From: Anita Gardner
Sent: 23 April 2018 09:19
To: Planning.Responses
Subject: FW: Planning Application EP / 7 /18 / PL

From: Lol Pilfold [REDACTED]
Sent: 19 April 2018 18:55
To: Anita Gardner; Malcolm Fitzgerald
Subject: Planning Application EP / 7 /18 / PL

Thank you for your reply to my email regarding the planning application EP/7/18/PL which I now understand has been granted an extension and will be decided by committee sometime in May of this year.

Elevations of new stircase to existing building

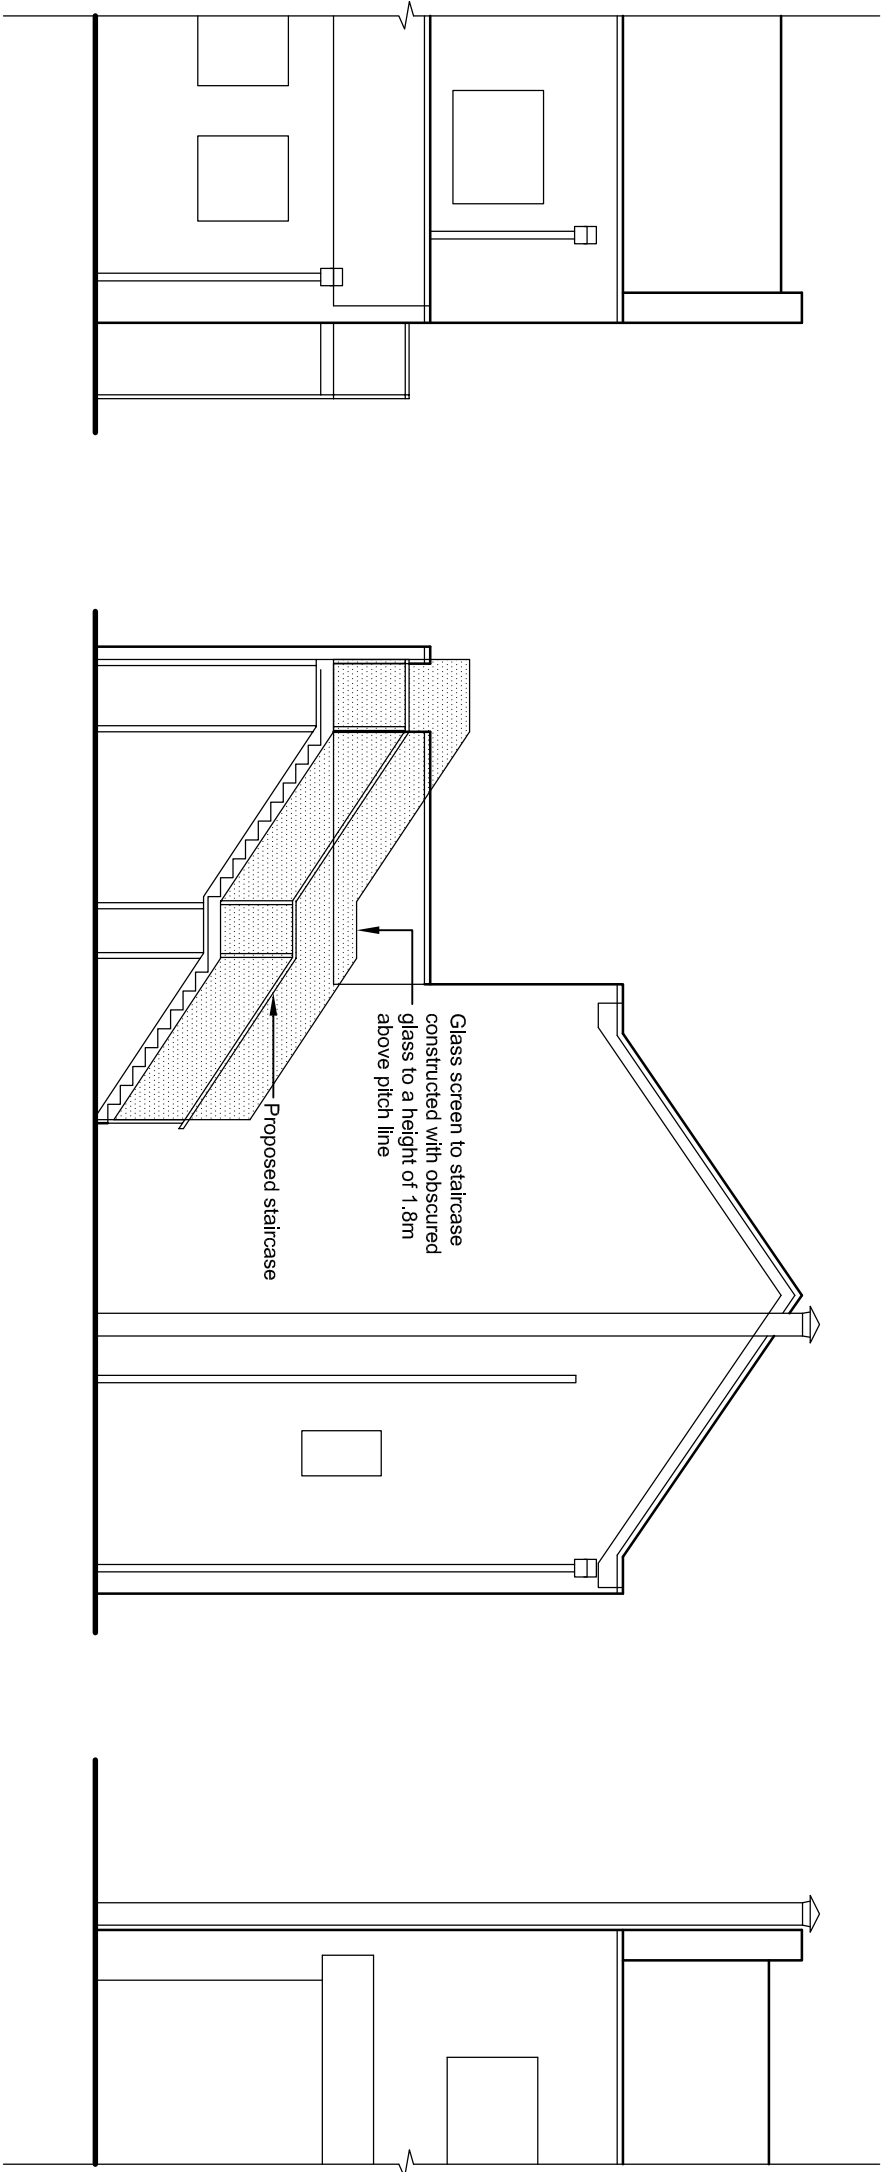
.. Firstly ,we have never considered the existing metal staircase used by Greenmanor's tenants to access their flats from their parked cars to be an "*impediment*" ..

It forms the only access to the rear compound for tenants living over the shops from where they have been allowed by the landlord to park their vehicles regardless of their leases..***I agree that this also a legal issue but the tenants safety needs to be considered in planning matters and the relocation of the staircase effects this ..***

The tenants of flat numbers 139 & 143 have no internal staircase to allow direct access to the front parade, even though it still appears on some plans.

The only original internal staircase to the front parade is situated between flats 129 & 133 close to where the proposed fire escape is to be sited.

The distance for the young family in flat 143 to the new proposed fire escape is unaltered at 34 metres and the landlord's most recent tenants adjacent to them in flat number 139 have a little one and are expecting another child soon.

If there is a fire in either of the 2 Northern end flats over the shops, numbers 129 (over fish & chip shop) & 133, then there is no viable safe means of escape for the residents if the fire escape were to be relocated as per the plan.

In these circumstances people including young children would be directed towards the hazard via the various obstructions on the balcony, the question being and one has to ask it "is that acceptable given recent events?"

DRAWING TITLE
Proposed Site Plan, Block Plan
and Location Plan

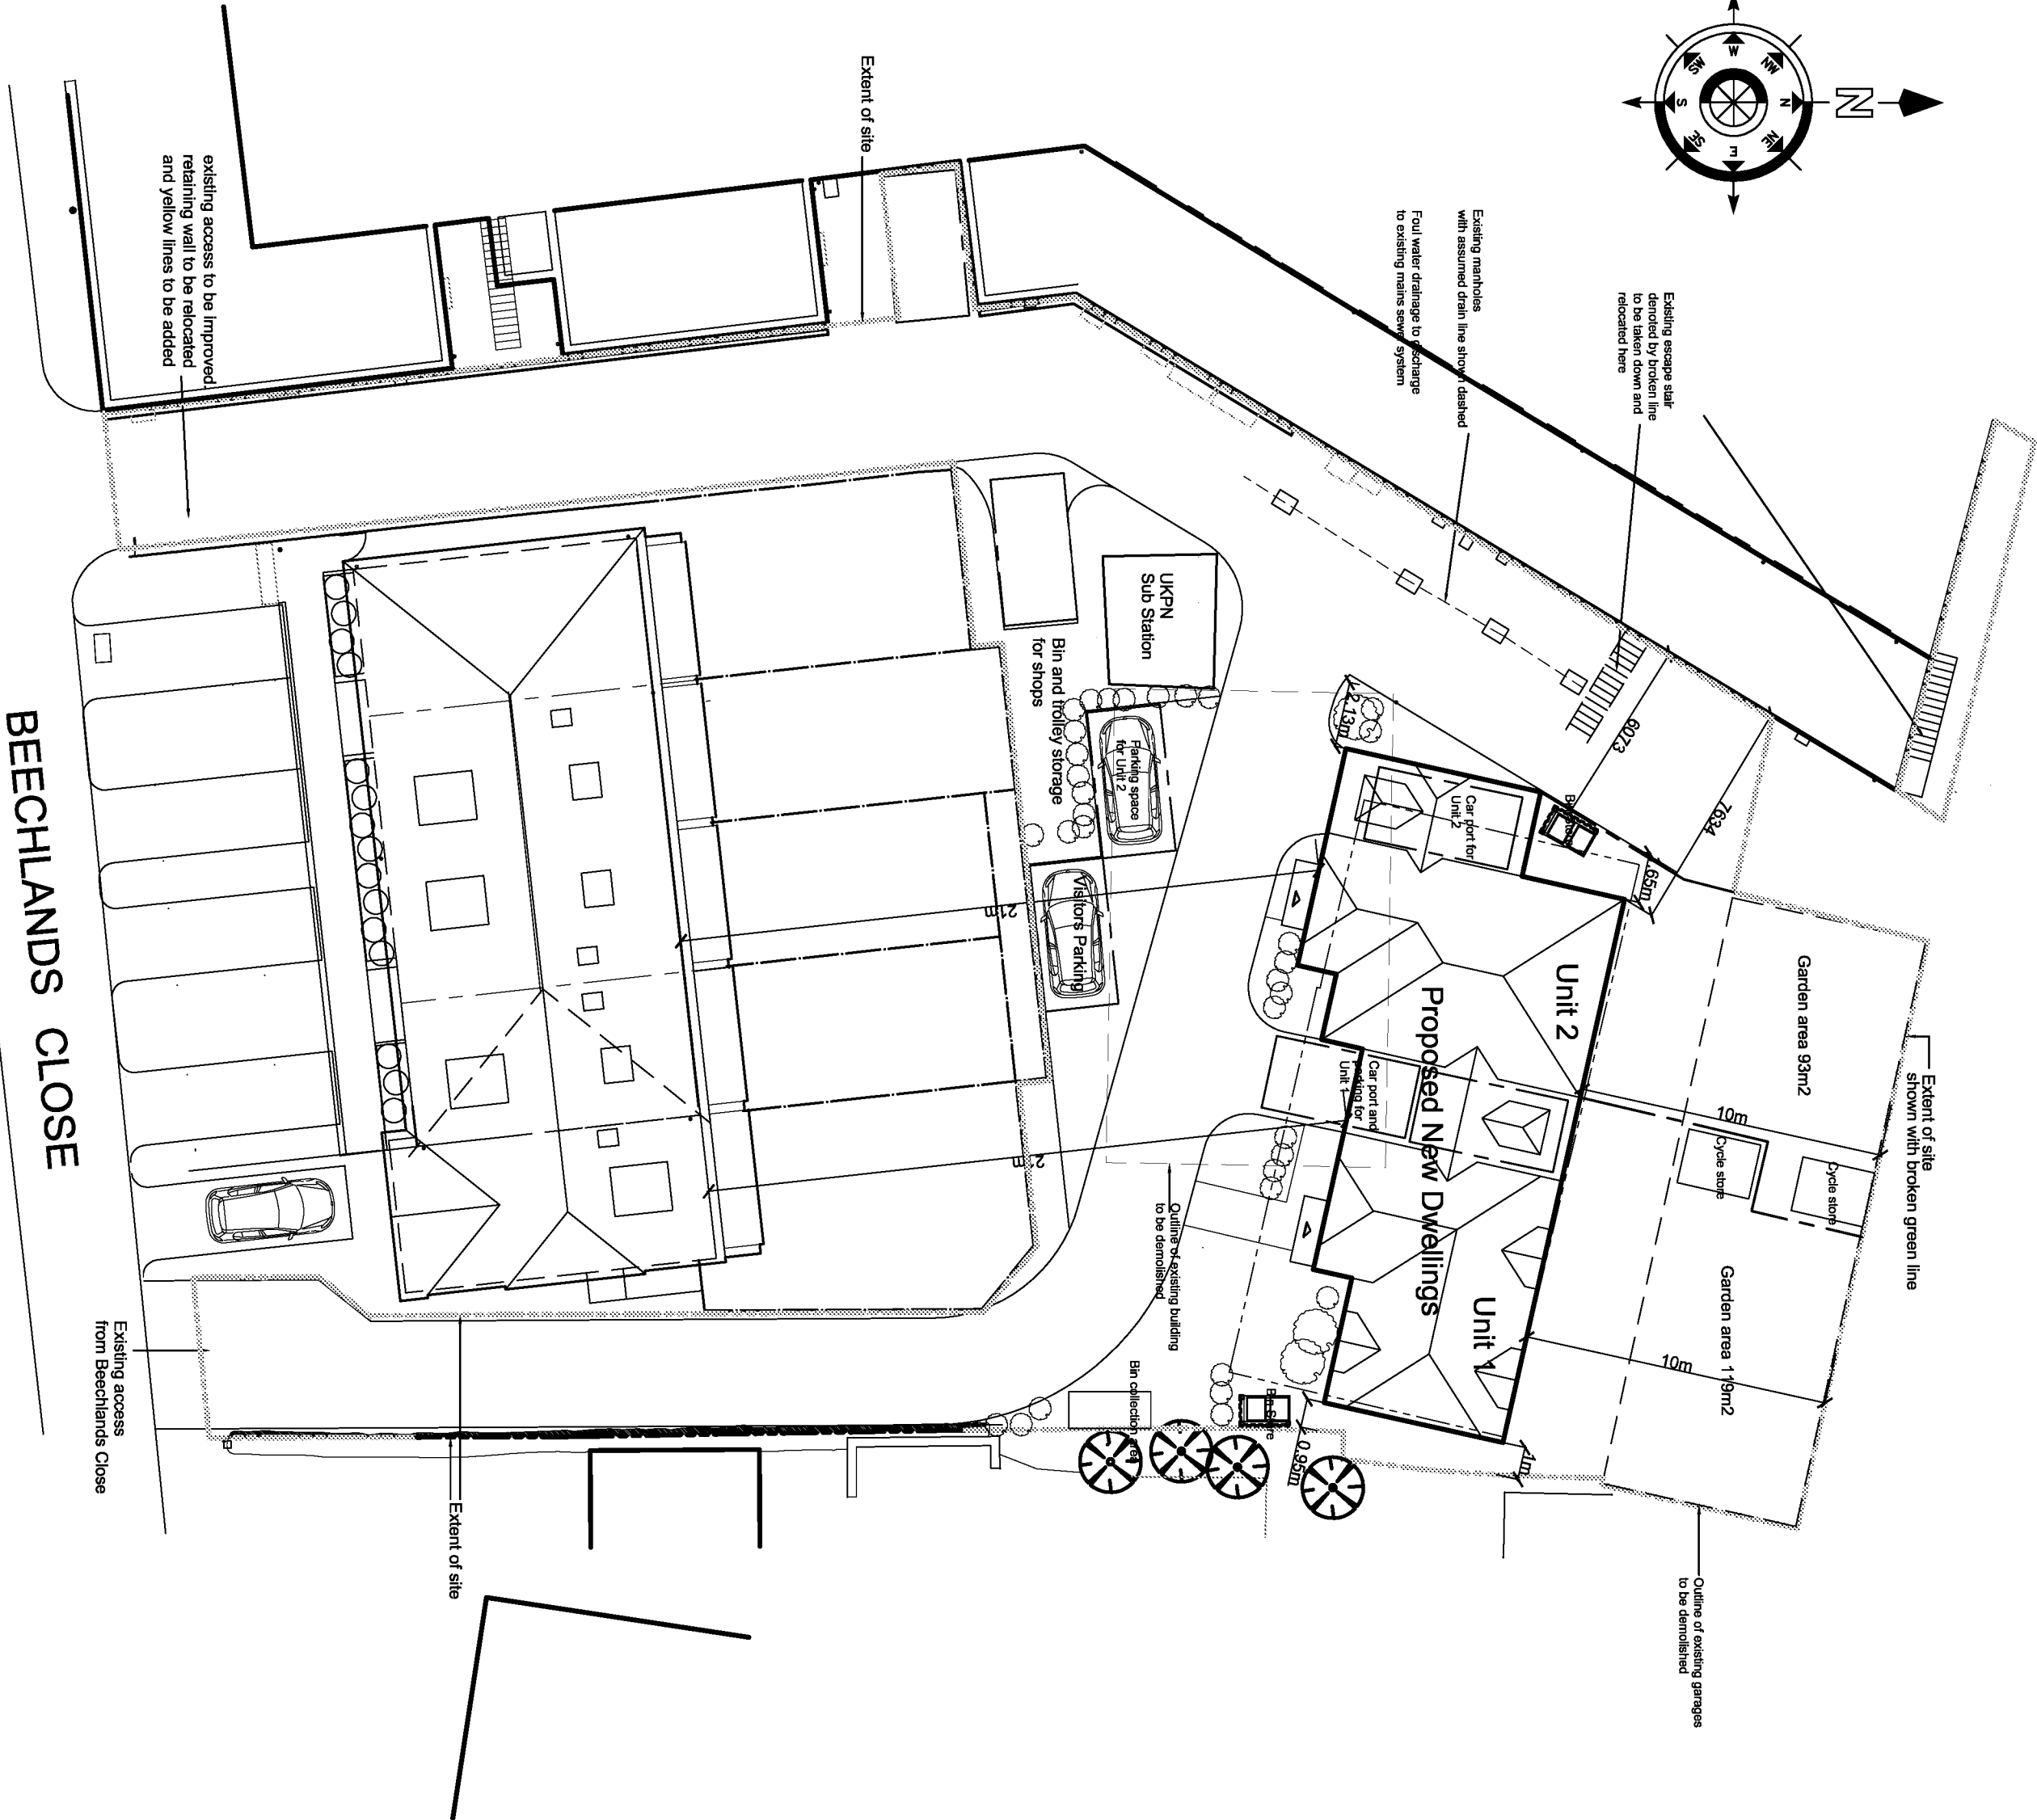
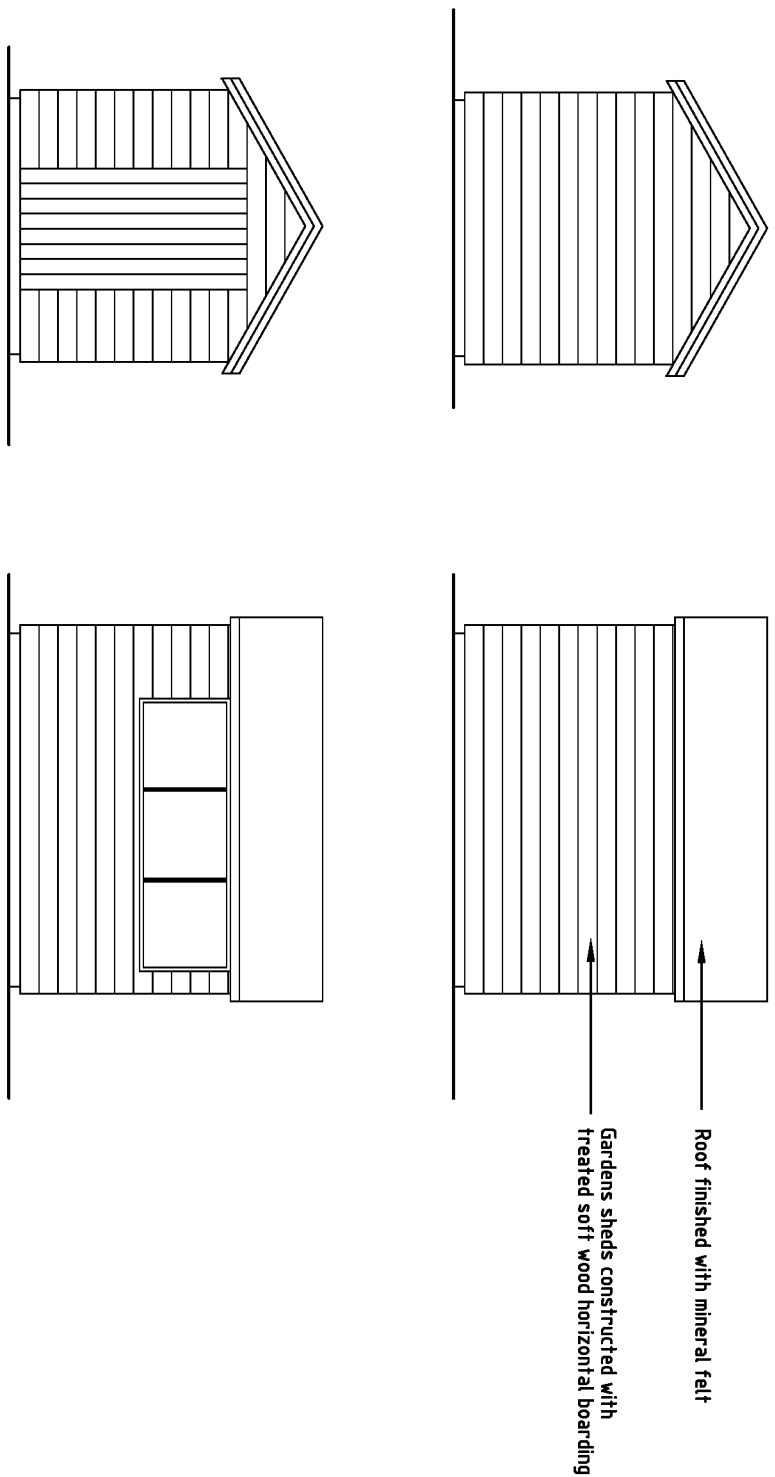
The "improved access" on the western side with yellow lines and ***"enforceable no parking"*** will further impact upon the tenants of the retail outlets who park there at present to load and unload, as they would have to utilise the parking at the front. This is supposed to be for customer parking and limited waiting time dependent, in addition it may not necessarily be available when required for loading and unloading .. ***again these vehicles should be included as being displaced ...***

Are the delivery vehicles/waste disposal vehicles using this new improved Western access route for the shops and flats able to access this narrow entrance ? ...and are they expected to reverse back out into Beechlands Close ? , clearly they will not be able to turn around and therefore, is that safe practice ?

Furthermore I would have thought that a door opening out onto this new vehicular non public route would have to be considered an obstruction/hazard to one party or another. This being especially so as the pedestrian access would be under a ***"not uncommon shared surface arrangement"*** and ***"no pedestrian zones would be***

required". Even the sensible inclusion of a pavement would not prevent a hazard to those walking past these doors. This would also further restrict the width of the route for vehicles having to use it.
